# Response to TfL Comments

Title: **Hayes Park West – Response to TfL Comments**

1. This note has been prepared by Iceni Projects on behalf of Shall Do Hayes Developments Ltd (The Applicant), as a response to comments received on the Hayes Park West Application. Comments were dated 19<sup>th</sup> January 2026.
2. The table below highlights the comments made by TfL in the left-hand column with the Iceni response on behalf of the Applicant in the right-hand column.
3. Should there be a need for further discussions, Iceni and the Applicant team would welcome the chance to discuss this further.

Lower ground floor showing routes to cycle stores and visitor stands in the landscape

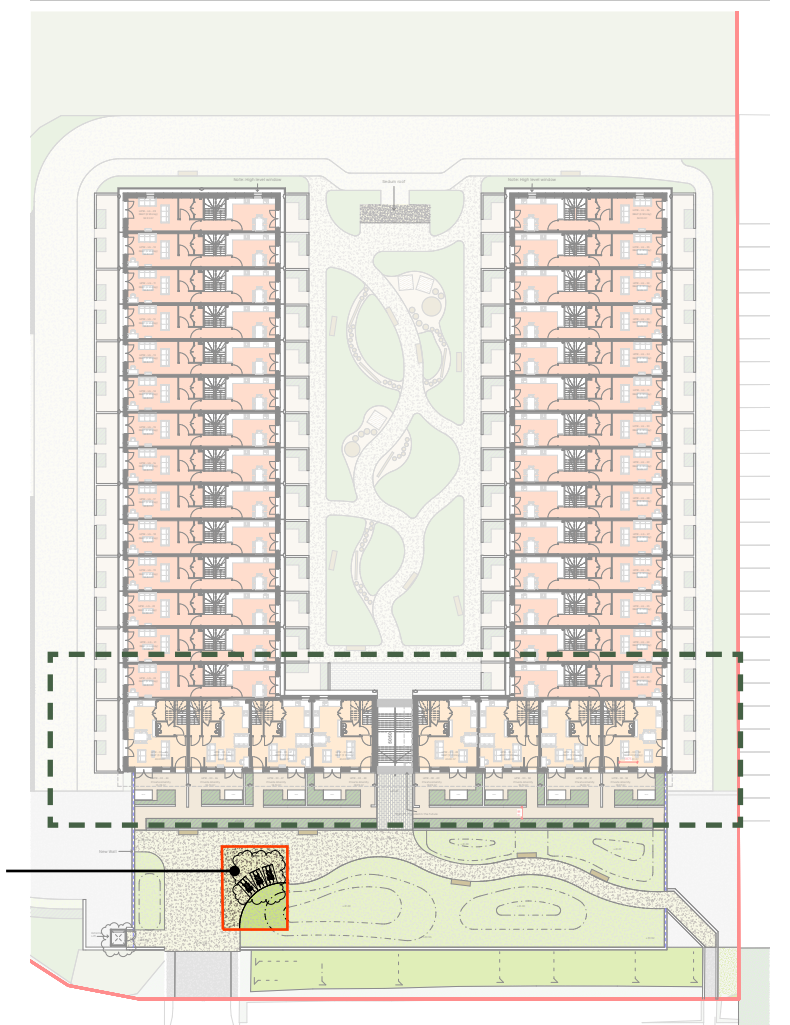
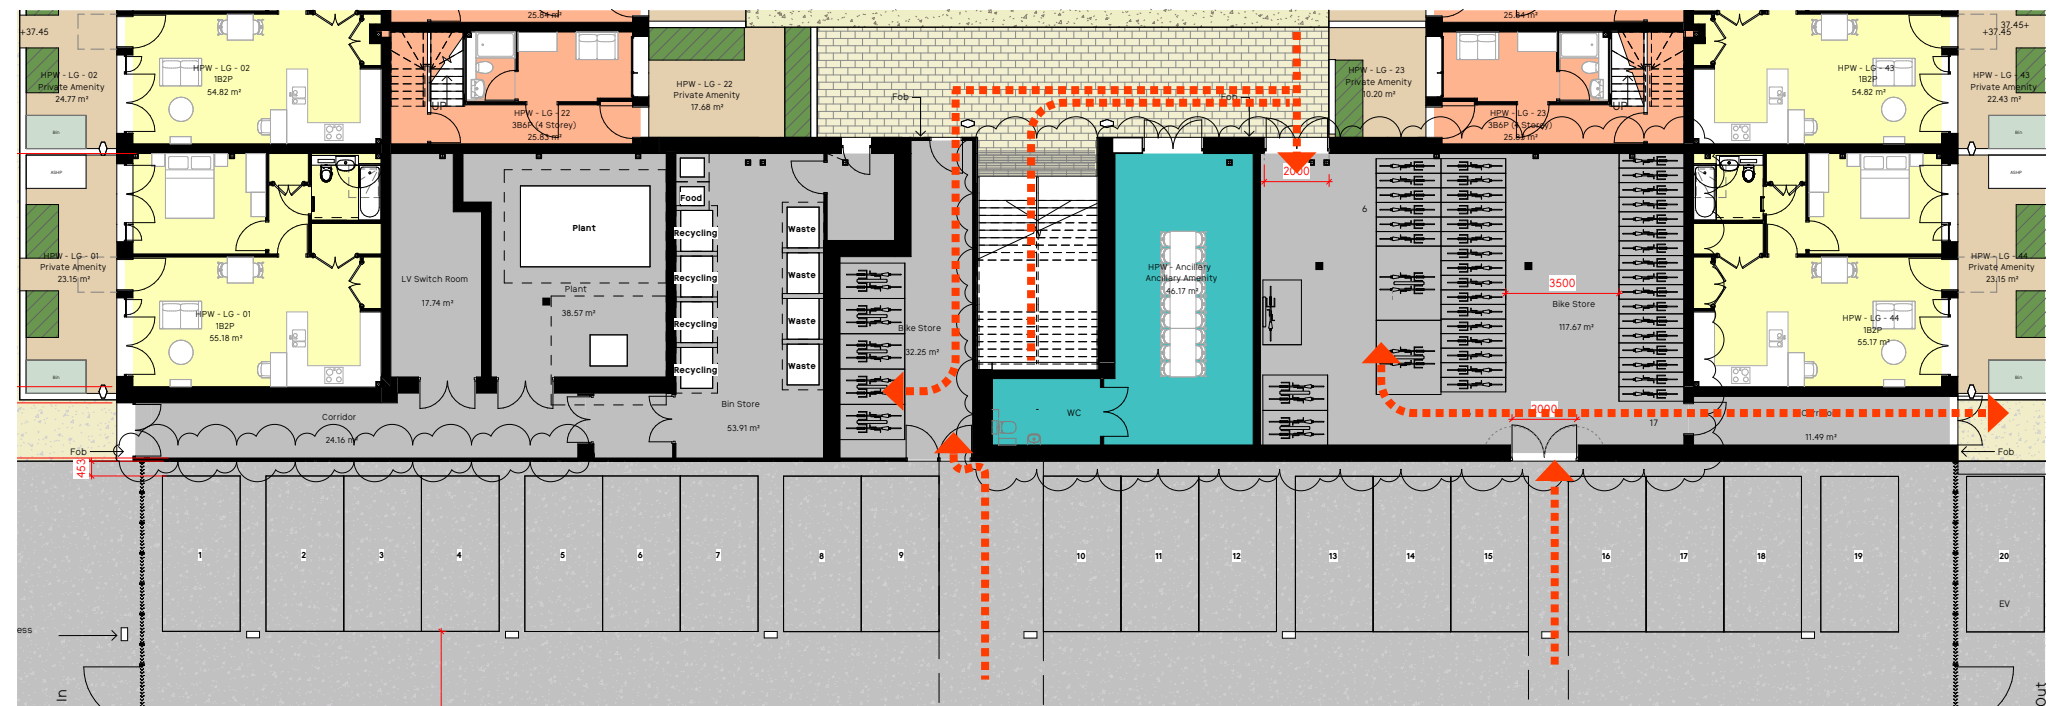
However, high-quality cycle parking is essential to support strategic modal shift. Based on the plans provided, TfL has concerns about the quality of provision. These can be summarised as:

- External door widths are currently shown as 1m; these should be a minimum of 2m, particularly as enlarged cycle spaces are located within these areas.
- Ideally, cycle stores should have a clear width of 3,500mm to accommodate double-stacking racks effectively.
- Where Sheffield stands are provided, the minimum centre-to-centre spacing must be 800mm to ensure usability.
- Short-stay spaces should be clearly identified on drawings and located within 15m of main entrances to ensure genuine usability of the spaces.

An updated plan has been produced by SEW (page 159 of the attached addendum), the architects, showing changes to the cycle

stores in order to be LCDS compliant. This demonstrates doors are 2m wide, that there is a clear width within the cycle store of 2.5m, which is the minimum allowed, 800mm between Sheffield Stands and highlights the location of short stay spaces as requested.
